# CITY OF ALBUQUERQUE

November 19, 2025

**Re: Albuquerque Collegiate Charter School**  
**9001 Sunset Gardens Rd. SW**  
**Albuquerque, NM 87121**  
**Traffic Circulation Layout**  
Engineer's Stamp 11-11-25 (L09-D032)

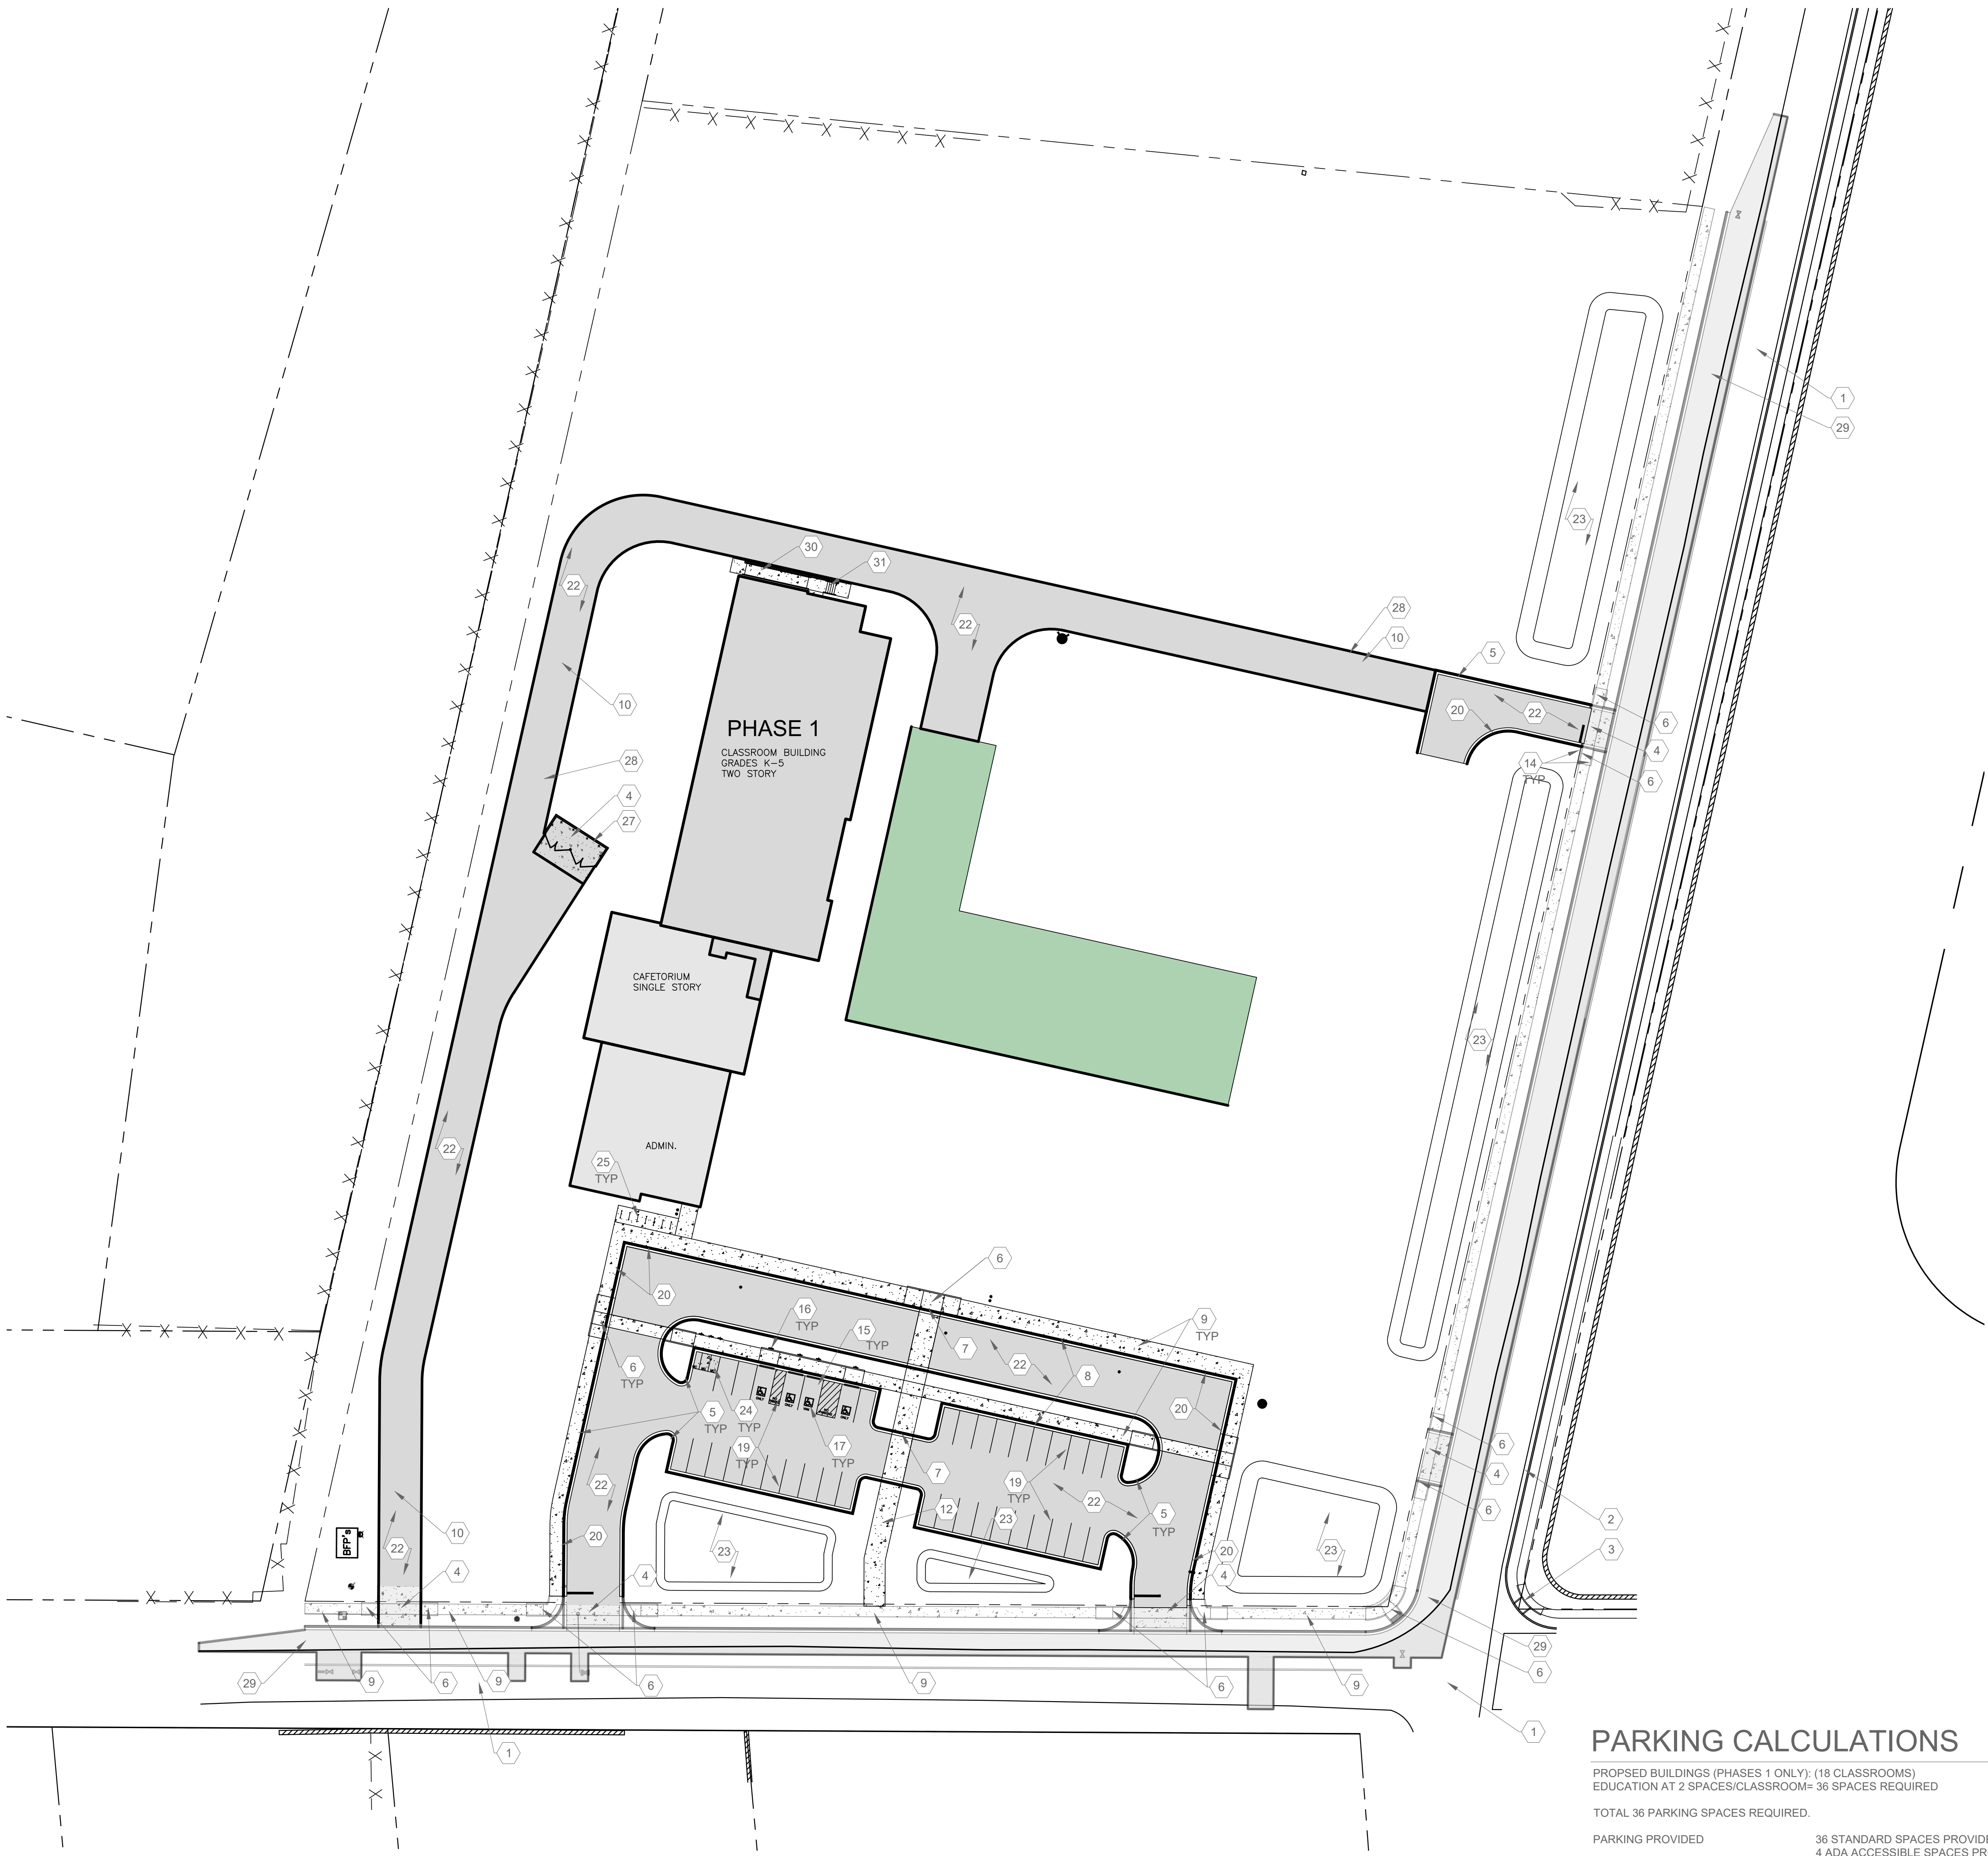
3. Identify street name, right of way width, medians, and curb cuts on Sunset Garden Road SW and 90<sup>th</sup> Street.
4. Show existing driveways on the adjacent properties and properties across the street from the site.

5. Callout school's drop off zone.
6. We noticed key note #4 for driveway details which reference detail drawing D4. Detail drawing D4 is for dumpster pad pavement. Please provide design details and standard drawings for all driveways meeting City's standards and requirements.

7. All accessways to the site from the adjacent roadways shall be ADA-compliant.
8. Please correct all site triangles and call out dimensions. Site triangles should be located at and behind the sidewalk.

11. Provide Zoning approval for parking calculations.
12. Show width and length for all proposed parking spaces. Some dimensions are not shown.
13. Call out parking stall barriers. Barriers should be provided to prevent vehicles from extending over public sidewalk, public right-of-way, or abutting lots.

14. Provide design details and City standard drawings for all ADA ramps. Also provide grade, slopes and cross slopes for parking areas, sidewalks, ramps, and landings.
